From: queencamel_clerk
To: [A303 Sparkford to Ilchester](#)
Subject: Written Representation from Queen Camel Parish Council
Date: 22 January 2019 18:12:11
Attachments: [Queen Camel Parish Council Written Representation.docx](#)

Please see attached the Queen Camel Parish Council Written Representation in respect of the A303 Sparkford to Ilchester Dualling Scheme DCO application. I would be grateful if you would acknowledge receipt of this email and attachment.

The Council has indicated its support for the proposed development at every stage of the consultation process but we have major concerns about three elements in the proposals, viz.

1. the absence of a detailed Traffic Management Plan for the construction phase;
2. the design of the Hazlegrove junction;
3. the absence of a local road parallel to the new dual carriageway.

A303 - RETENTION OF EXISTING ROADS

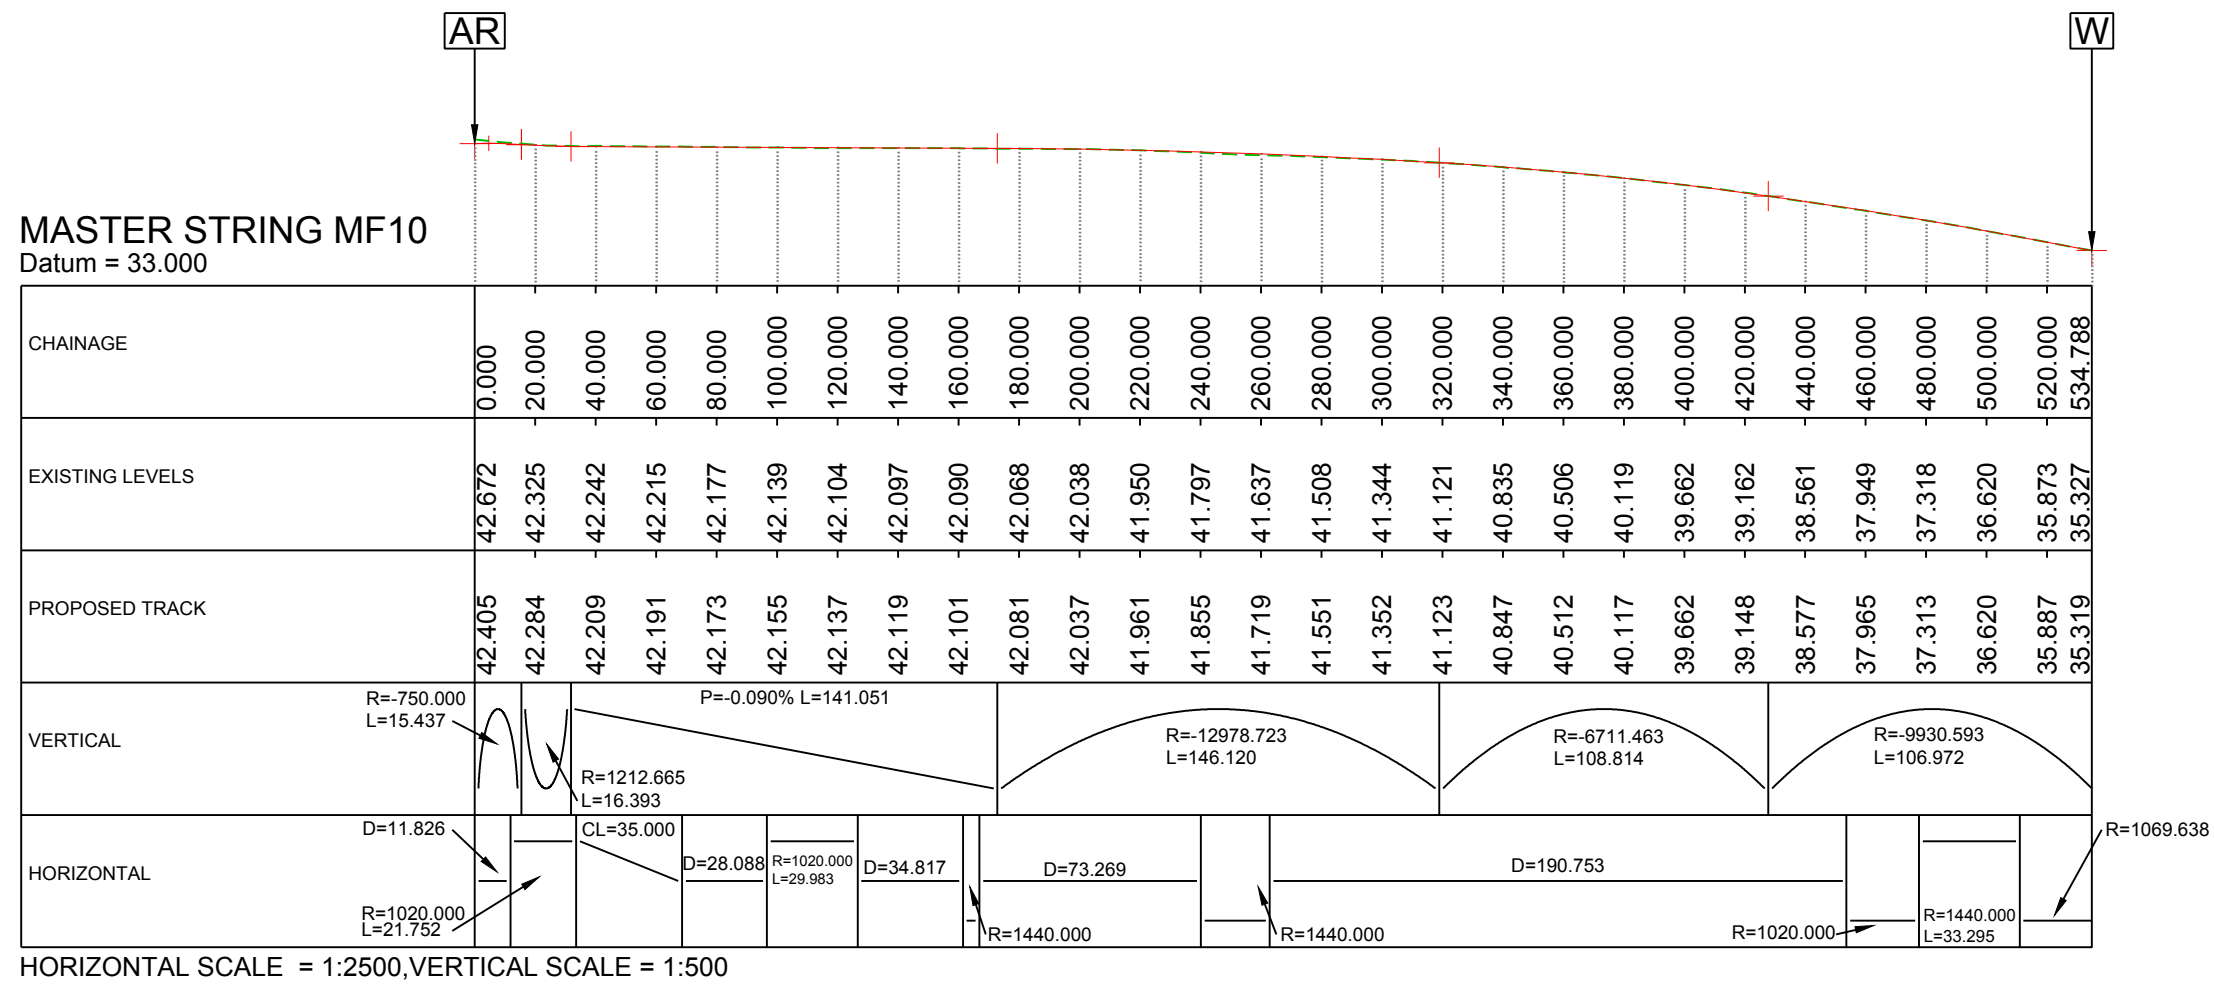
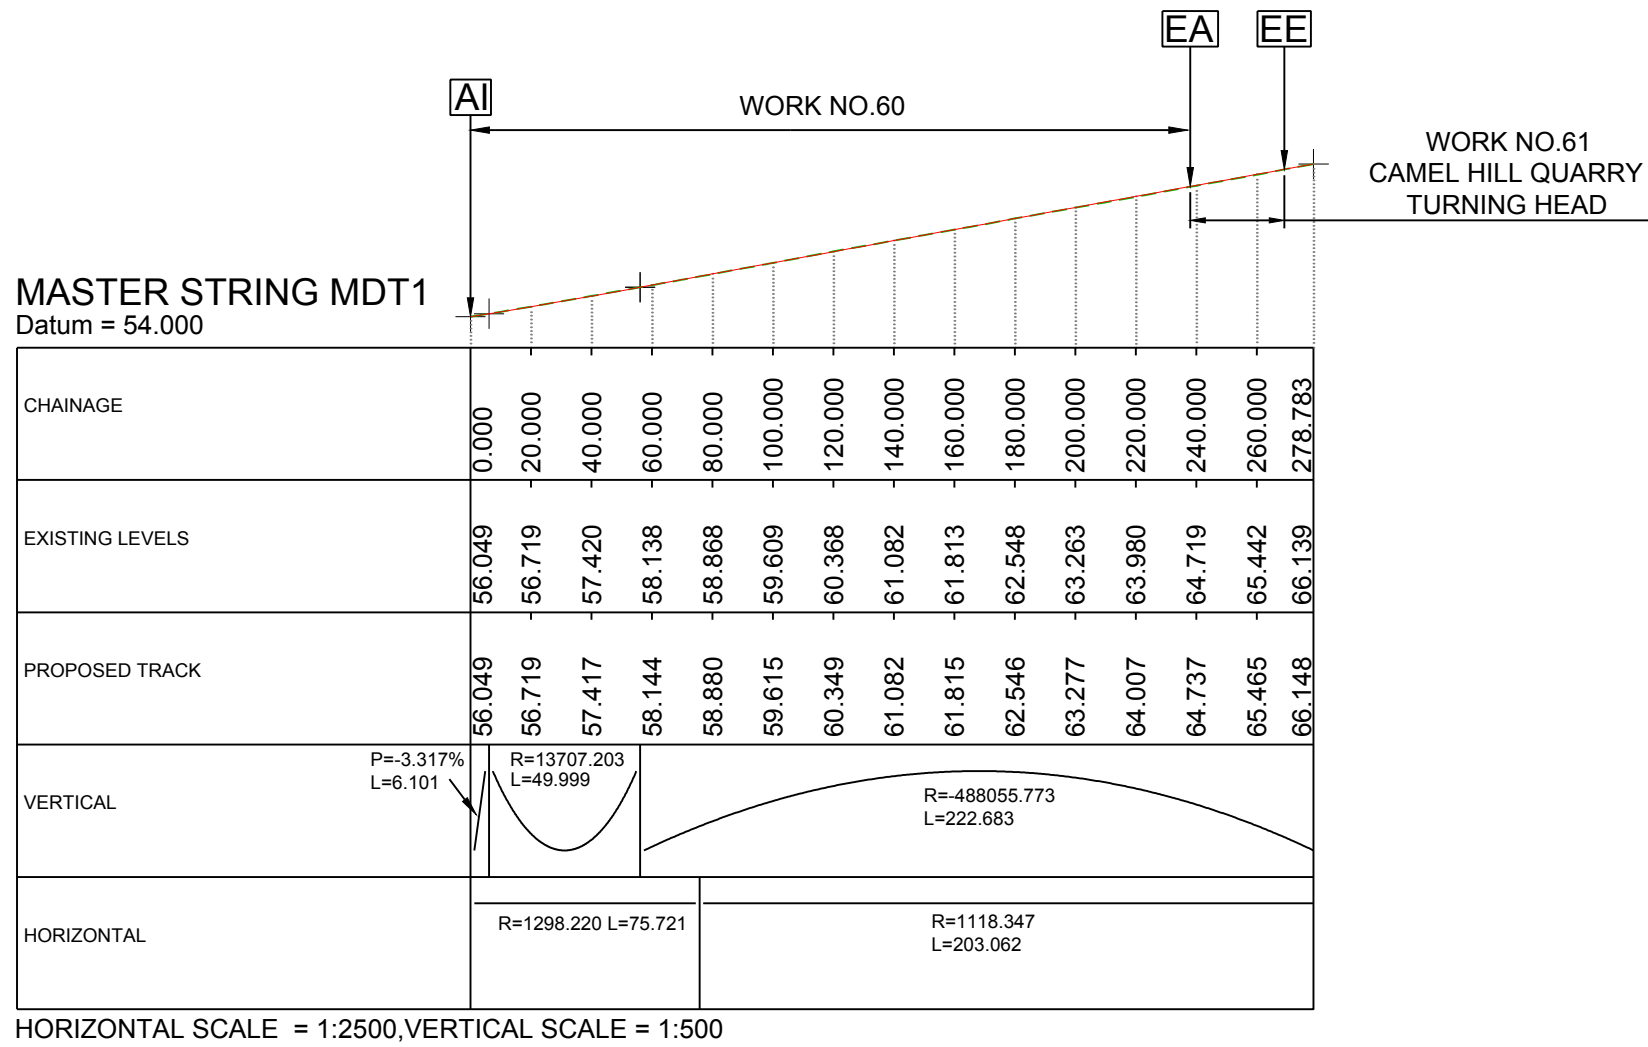
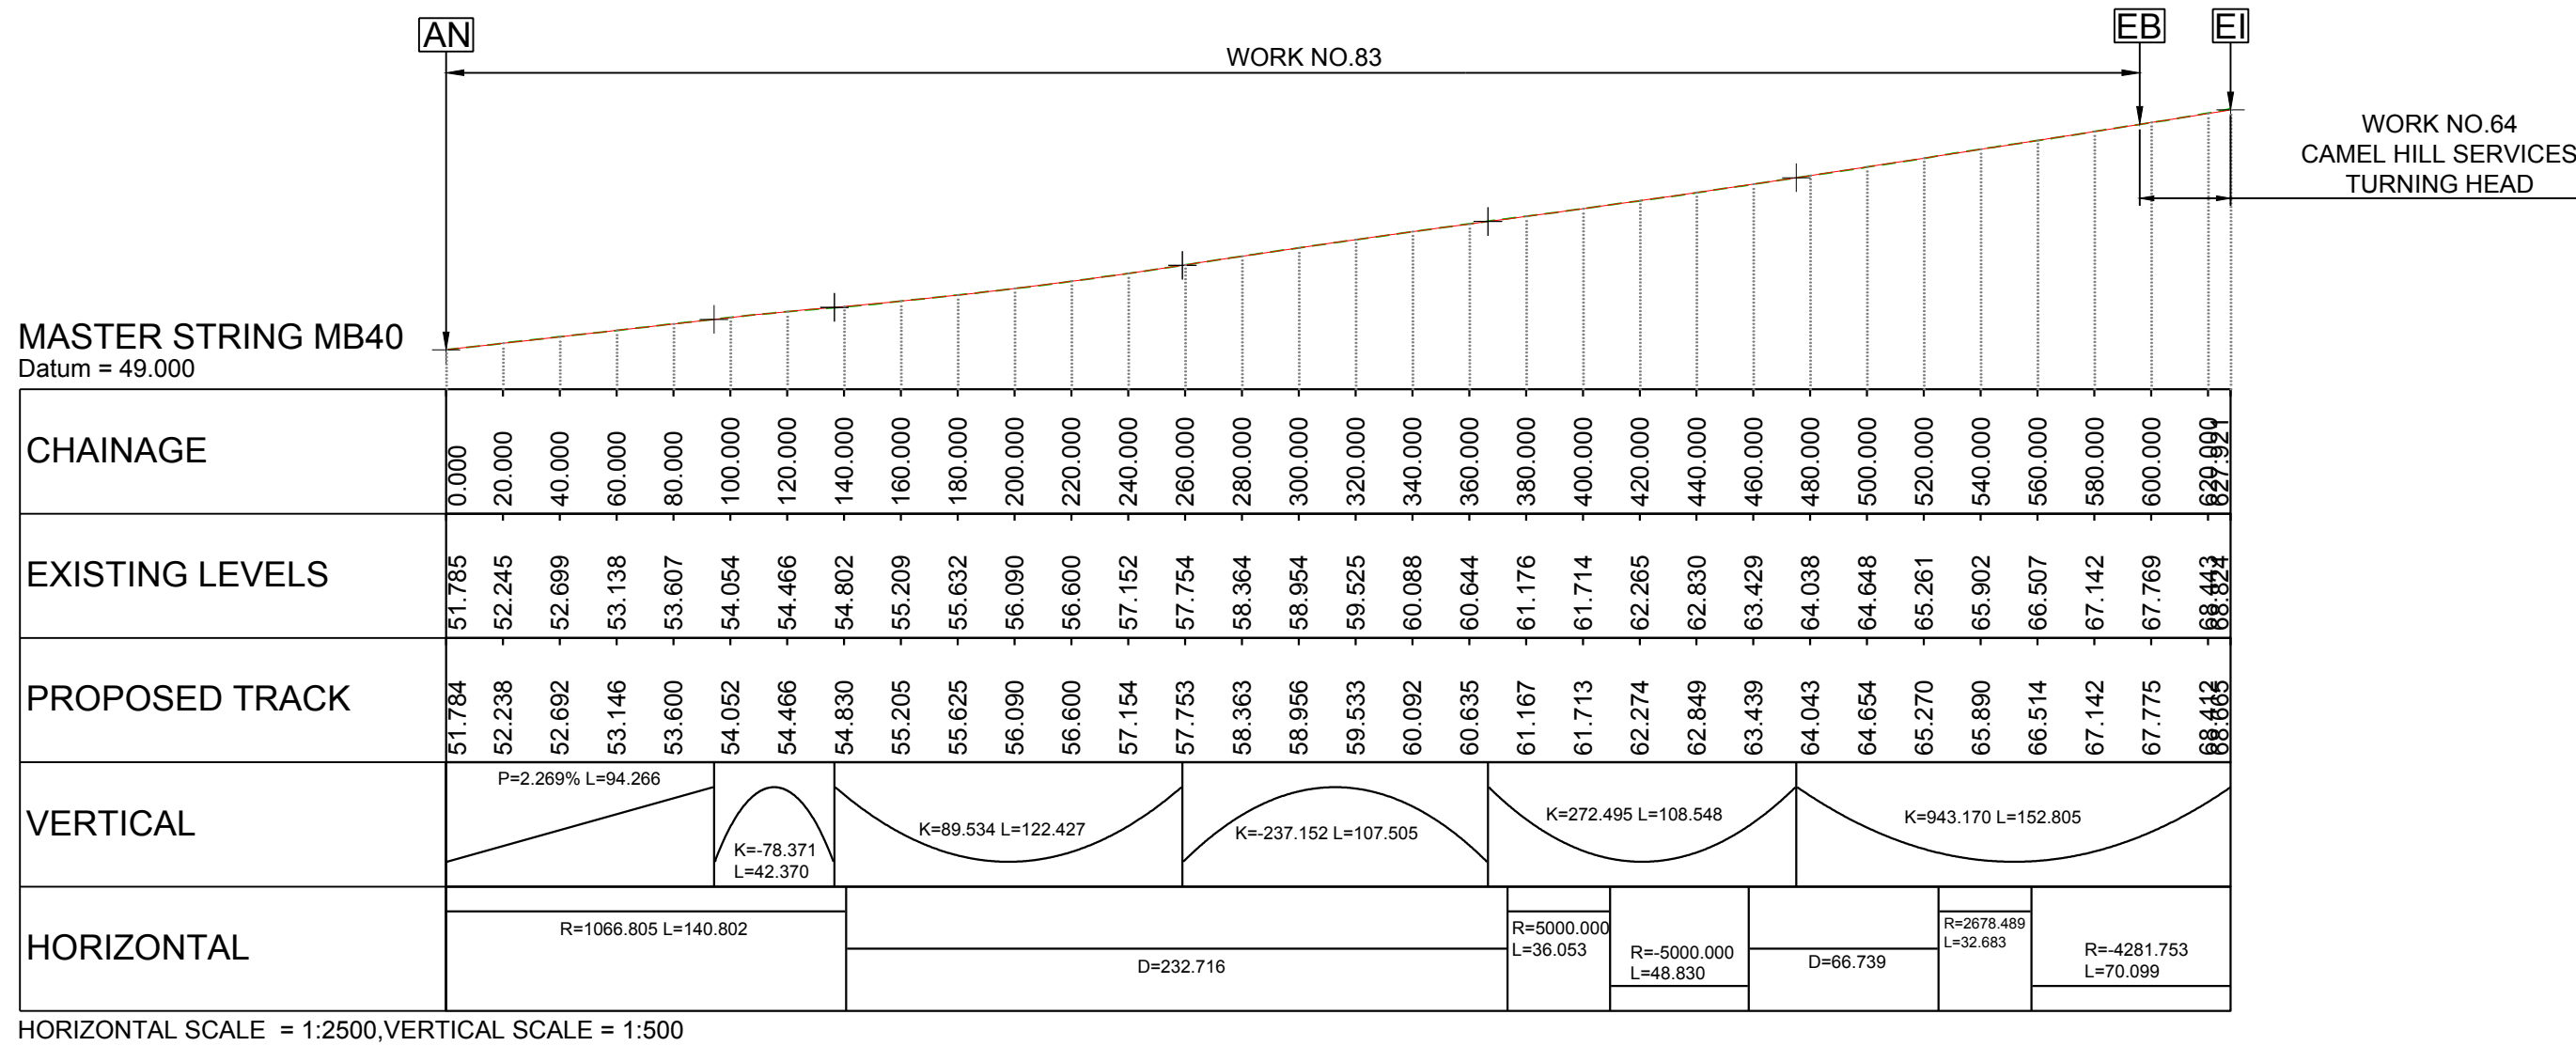
3. Parallel Road. The application fails to give serious consideration to the advantages of retaining the carriageway of the existing A303 for local traffic alongside the new dual carriageway between Hazlegrove and Camel Cross. Such a 'parallel road' would:

- 1) Reduce the need for speed limits and road closures during construction, resulting in less congestion on the A303 and local roads.
- 2) Reduce the cost and the duration of construction.

- 3) Enable heavy farm traffic to access Traits Lane and Eyewell Farm from the north (as currently), keeping it off narrow Blackwell Lane, and obviating the need to alter and enlarge the Traits Lane - Blackwell Lane junction.

- 4) Keep Traits Lane, Gason Lane and the spur road past the Shell Filling Station as through roads. Under the existing proposals they would all become 'dead-ends', attracting fly-tipping and anti-social behaviour

The Applicant maintains that there is insufficient width between the Scheduled monument and MOD land on Camel Hill to accommodate a parallel road alongside the dual carriageway, and that negotiating a land-purchase from the MOD would jeopardize the programme (*Draft Statement of Common Ground, doc.8.10, Rev.1*). The Council asks the Examining Authority to examine these contentions closely as information presented by Mr Norman casts doubt on both.
